11 April 2019

16258

**RE: Response to Request for Information for SSD 5175 (Mod 4) and SDD 8588 (Mod 2)
Eastern Creek Business Hub**

Figure 11: Vehicle access

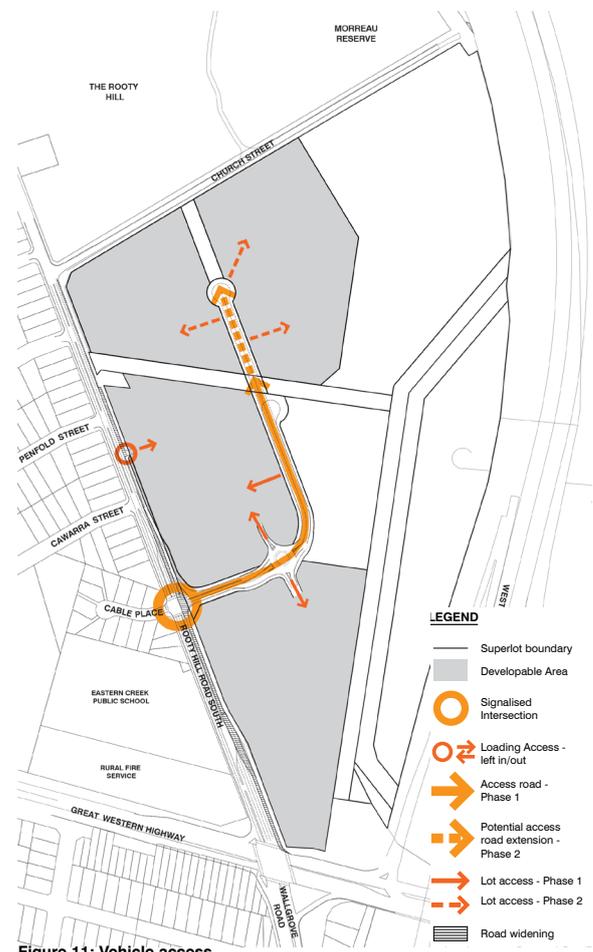
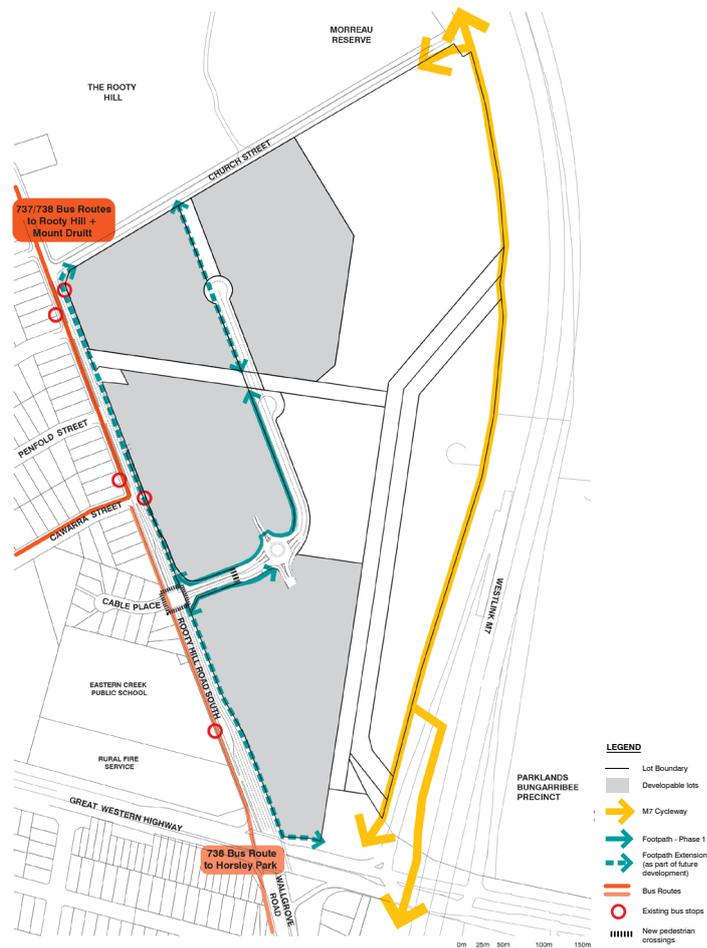
DPE Comment	Response
Update maximum estimated gross floor area (changes under Mod 3) (page 8)	This has been addressed in the updated Urban Design Guidelines (Attachment B).
Update figures 11 and 12 to reflect proposed new roundabout (page 12)	This has been addressed in the updated Urban Design Guidelines (Attachment B).
Update figure 29 to reflect proposed new infrastructure works (page 23)	This has been addressed in the updated Urban Design Guidelines (Attachment B).
<p>In section 3.1.2, a new point is added stating 'lots are to have a minimum land area of 4,000 sqm'. However, Figure 30 and 31 shows lots with an area of 0.27 ha and 0.15 ha, which are below 4,000 sqm. Clarify how the proposed subdivision of super lots as shown in Figures 30 and 31 would comply with this control (page 24)</p>	<p>The minimum land area of 4,000sqm has always been part of the Design Guidelines. This text was originally coloured red under Mod 2 as it was previously proposed to be removed, however was reinstated at the request of Council. The text has been changed back to black in the updated Urban Design Guidelines (Attachment B) for clarity.</p> <p>As shown at Figures 31 and 32 of the originally approved Design Guidelines, dated February 2014 (extracted below), the lots were always intended to be further subdivided into smaller areas. Accordingly, it is understood that the 4,000sqm minimum land area applies to the superlots, being; Lots 1, 2 and 3. The proposed amended Subdivision Plan of Lot 2 has an area of 4.11ha and therefore complies with the control.</p> <div style="display: flex; justify-content: space-around; align-items: center;">   </div> <p style="font-size: small; margin-top: 5px;">Figure 31: Large Lot Subdivision Figure 32: Medium Lot Subdivision</p>

Figure 52: Development Control Plan - Lot 2 (not to scale)

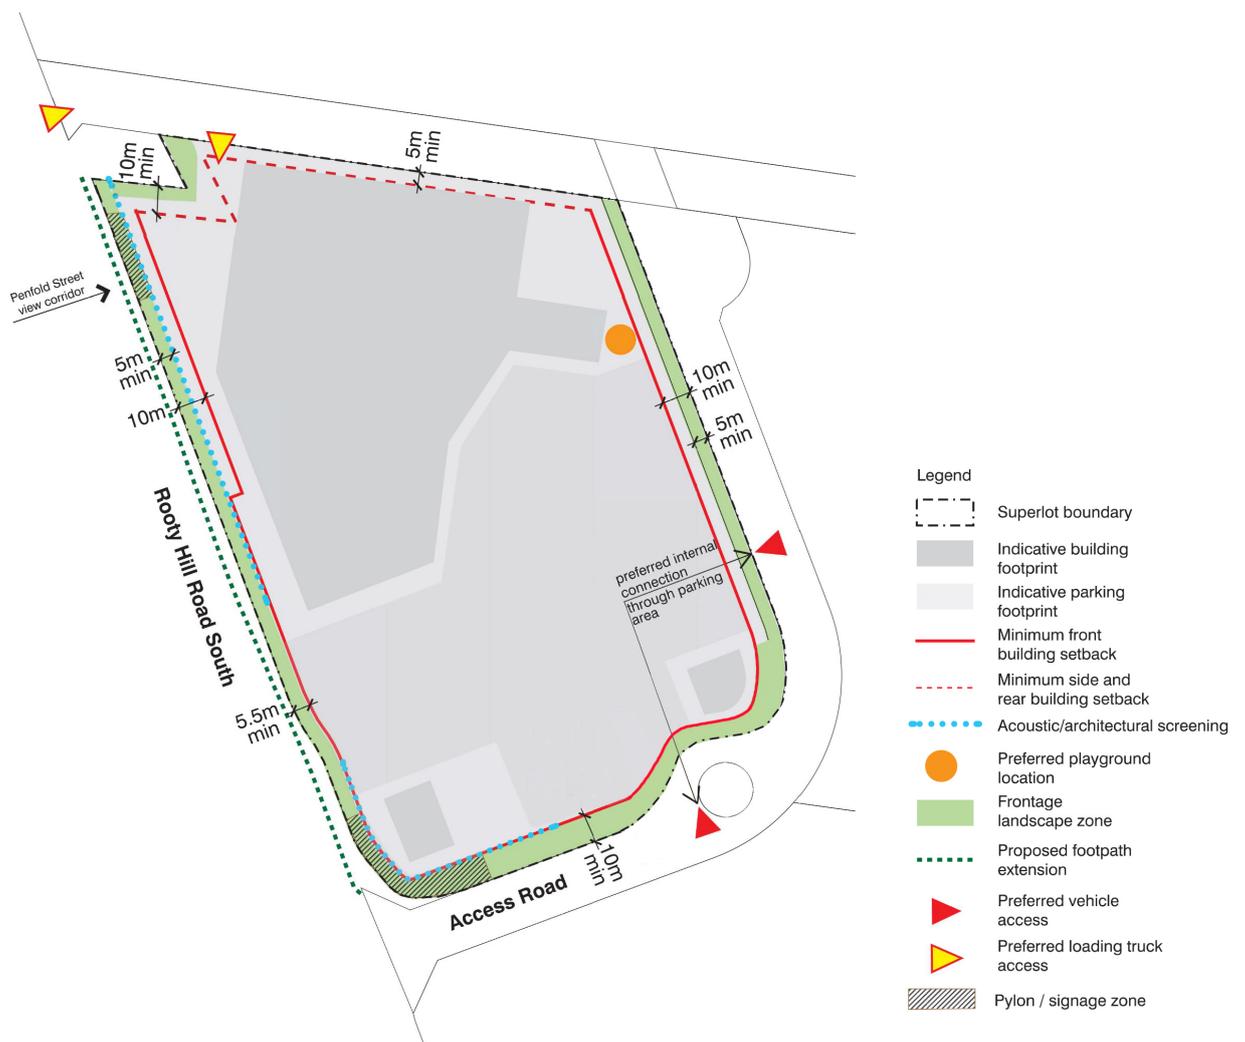
DPE Comment	Response
<p>Clarify the reason for control C6 being added to Section 3.6.16, as the intent is not clear. Also Figure 52 has not been updated to reflect the current modifications to Lot 2.</p>	<p>As above, this change was approved as part of a previous modification application and has now been changed to black text in the updated Design Guidelines (Attachment B).</p>
<p>Stormwater</p>	
<p>Provide further information to show how the proposed stormwater treatment system will meet the environmental targets of Part J of the Blacktown City Council DCP 2015</p>	<p>An updated Stormwater Summary Report is included with the Revised Stormwater Package (Attachment C). This report outlines how the proposed system achieves the environmental targets of Part J of the Blacktown DCP 2015 in terms of the Deemed to Comply OSD spreadsheet tool and the water quality targets.</p>
<p>SSD 8588 Mod 2</p>	
<p>Parking</p>

| LOT 2 PARKING STAGE 1 |     |

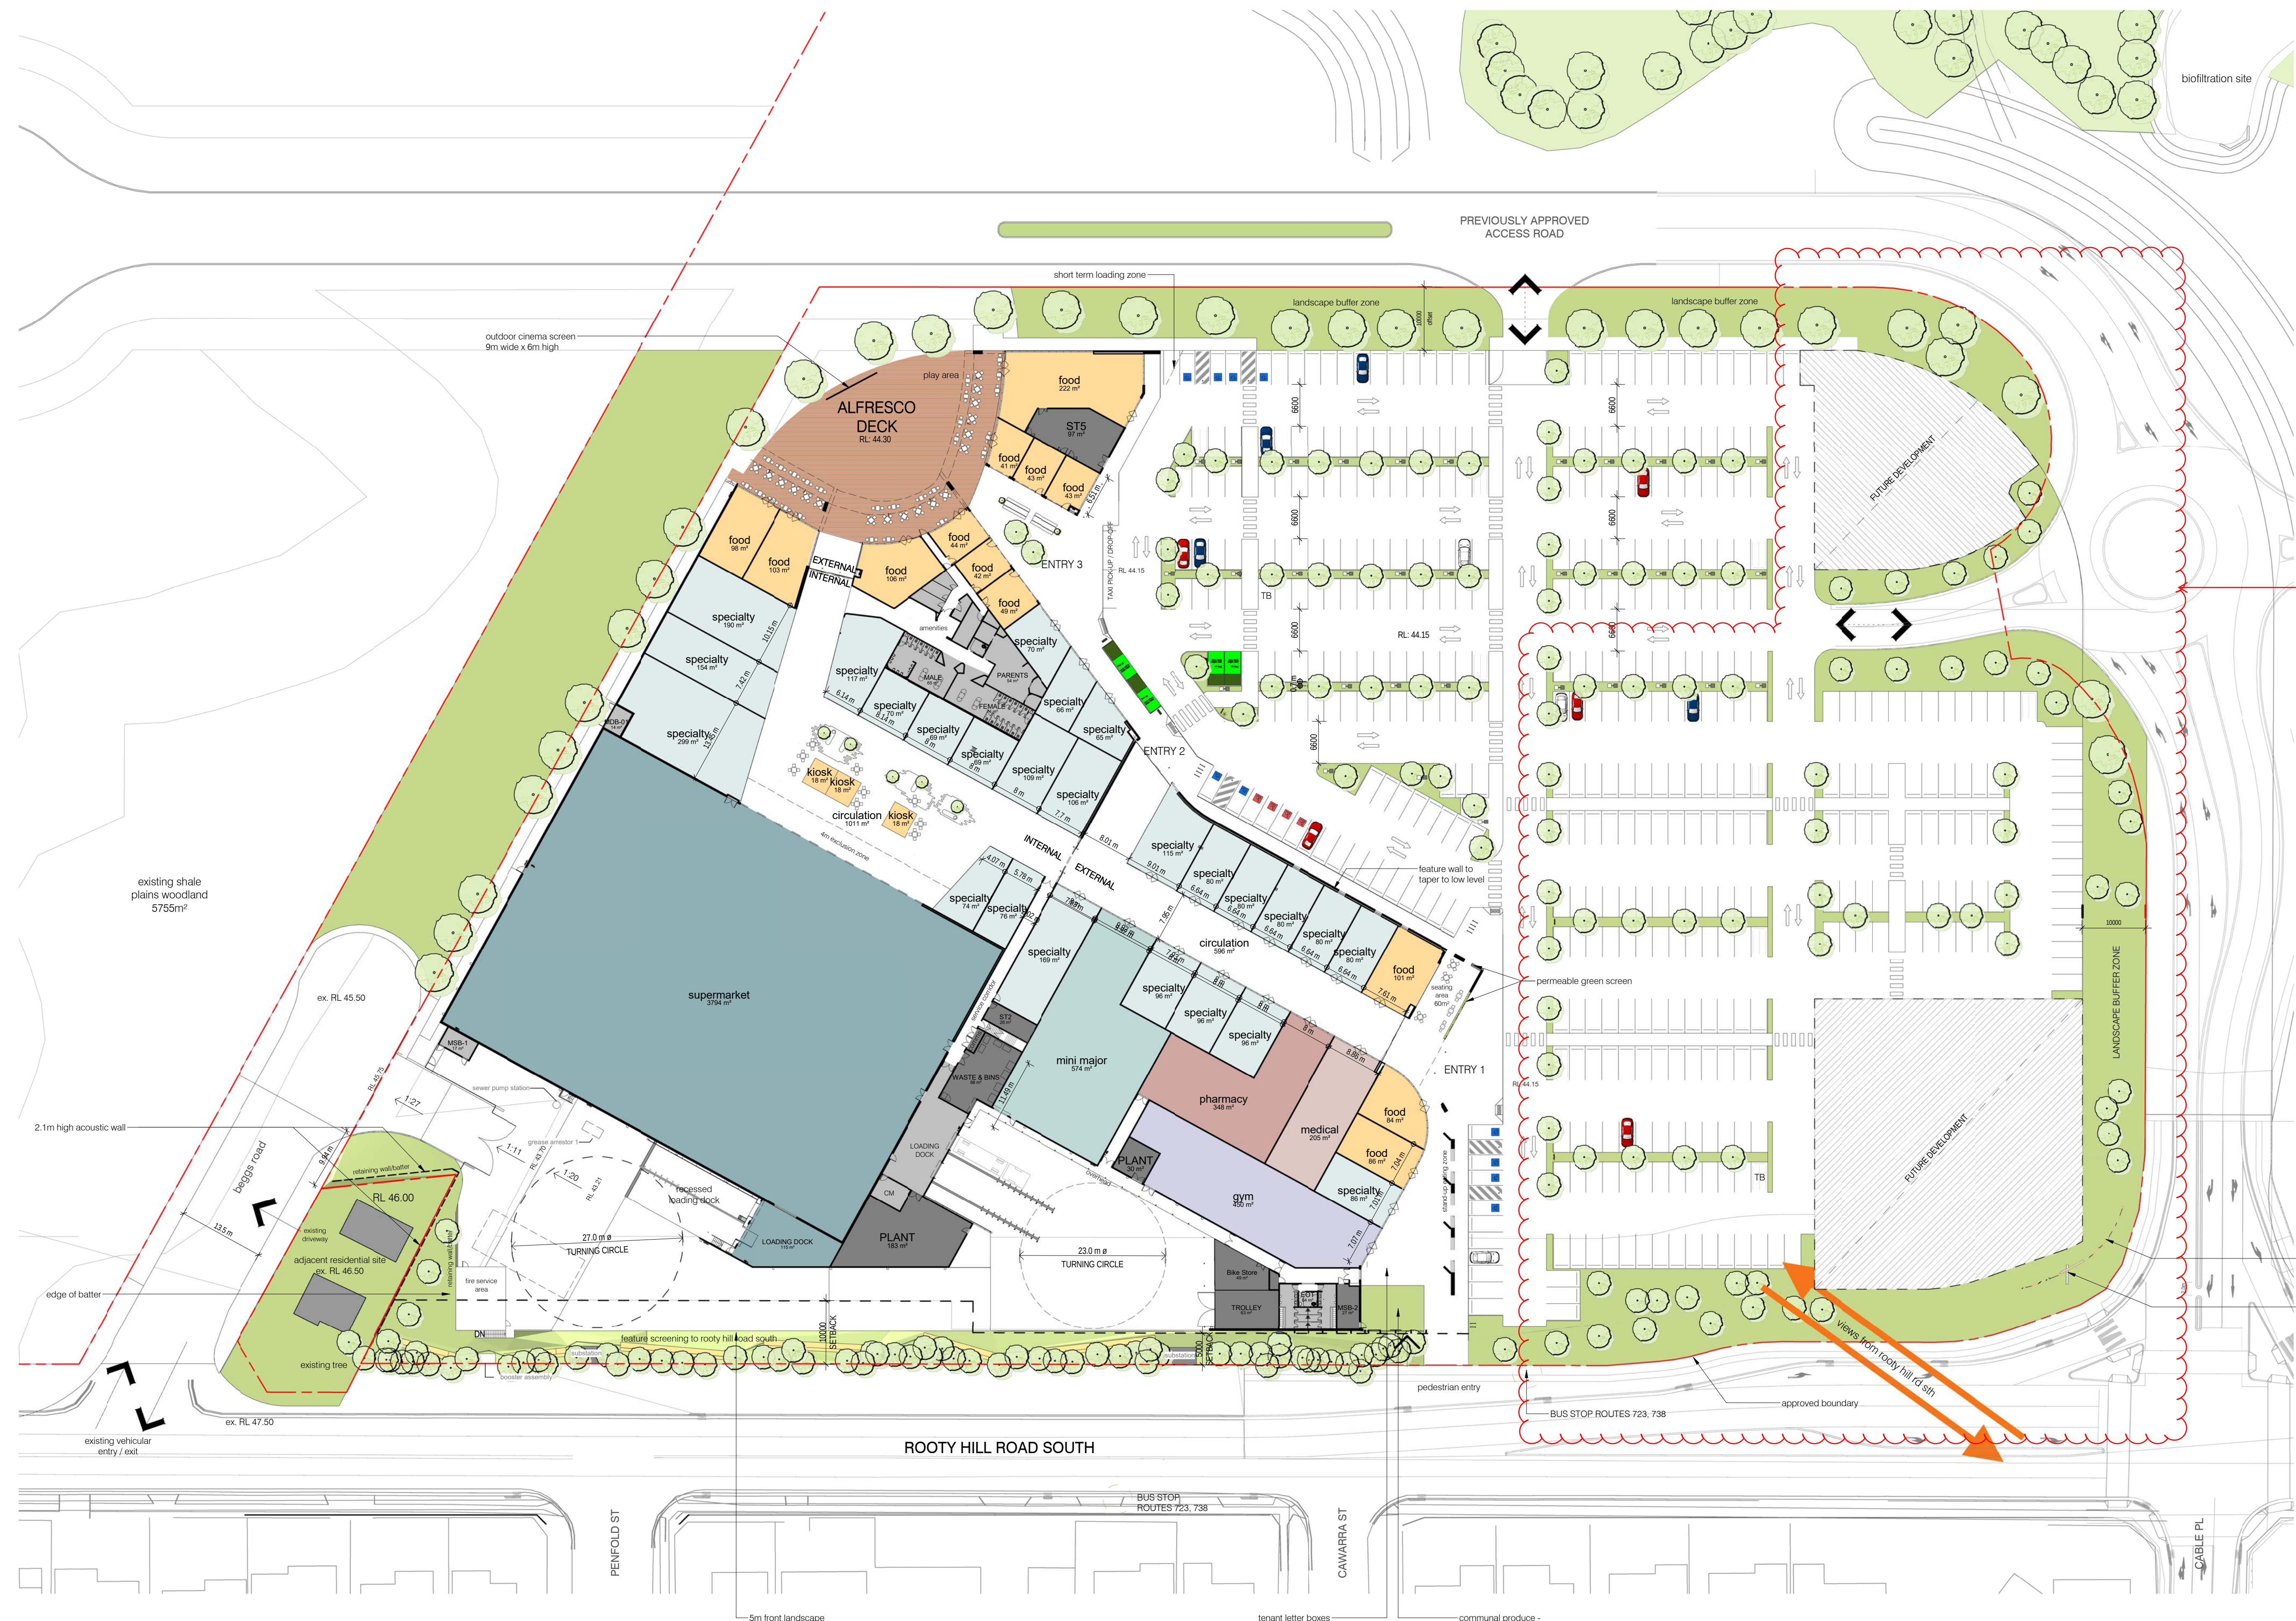
<p>Clarify how the Lot 2 Parking Stage 1 table on the Architectural Plan complies with the number of car spaces required by Condition B11</p>	<p>It is proposed to amend Condition B11 for consistency with the proposed new parking numbers. As above, the development will continue to comply with the minimum spaces required by the Design Guidelines.</p> <p>In addition, it is noted that SSD 8588 approved parking for all uses across Lot 2. This included the general retail uses as well as a number of 'ancillary uses', including the medical centre, indoor recreation facility (gym) and future development site (currently proposed for a child care centre). However, condition B11 only references 'retail car parking spaces' which may have the unintended consequence of excluding parking for the ancillary uses, including the future child care centre.</p> <p>Therefore, for the purpose of clarification, and to avoid any unnecessary future modifications, it is proposed to further amend Condition B11 to also reference the approved 'ancillary uses'. The proposed new wording for Condition 11 is:</p> <p><i>B11. The development shall provide car parking in accordance with the following requirements:</i></p> <ul style="list-style-type: none"> a) a total of 433 432 on-site car parking spaces comprising: <ul style="list-style-type: none"> i. 418 417 retail/ancillary use car parking spaces ii. 10 accessible car spaces iii. 4 pick-up spaces for the supermarket tenancy iv. 1 pick-up/drop-off space

Figure 1 – Provides clarity around the decreased impact to Shale Plains Woodland (SPW) and the removal of any impacts on Alluvial Woodland (AW), providing decrease in impacts to native vegetation.

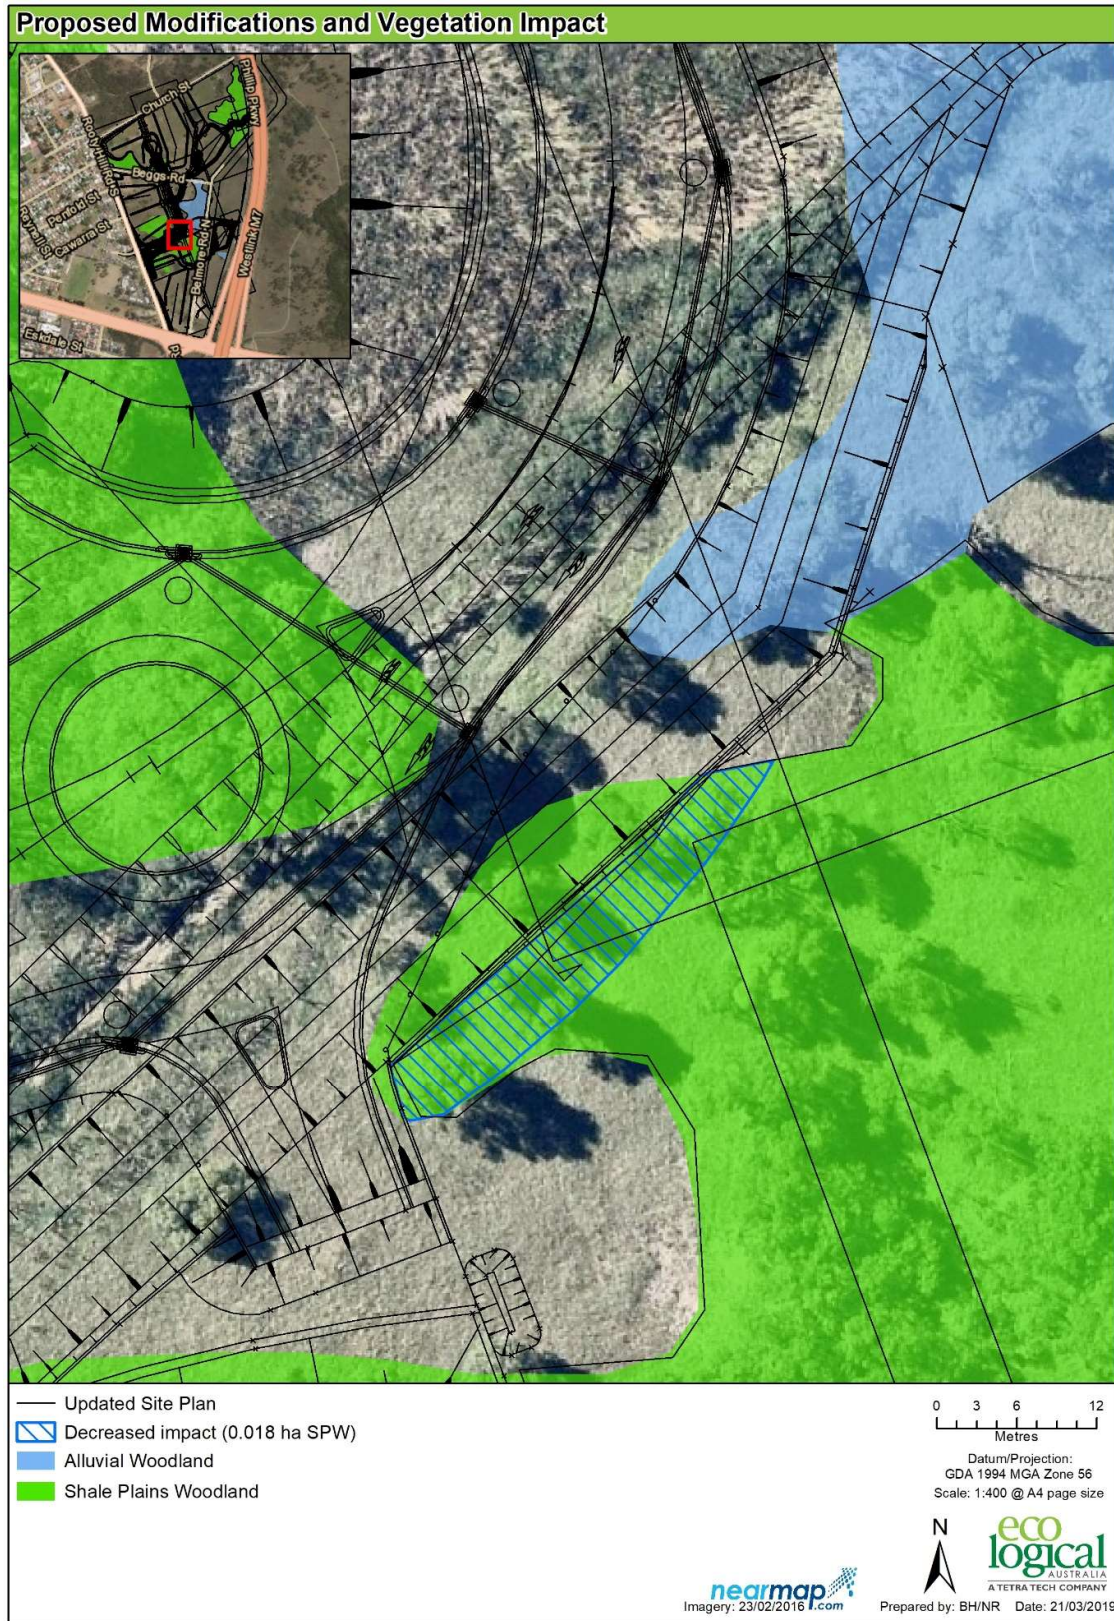
DPE Comment	Response
<p>forms this open drainage channel. OEH requires a clear plan showing the proposed offset area on site, that also clearly shows the proposed modifications and the vegetation area impacted at a scale that is clearly visible. The plan provided in Ecological Australia's document dated 26 September 2018 extracted below is unclear.</p>	
<p>The comparison of the 'approved' and 'proposed' plans for the design of the Stage 1 lot as shown in Figure 2 extracted below, indicates that the overland flow channel mark in green around the proposed Building 1 envelope is smaller compared with the approved diagram. If this overland flow channel forms part of the on-site offset, it appears that the offset has been reduced in size. OEH requires clarification on this aspect of the proposal.</p>	<p>As noted above, Ecological Australia has confirmed in their letter at Attachment F that the overland flow channel does not form part of the offset area.</p>
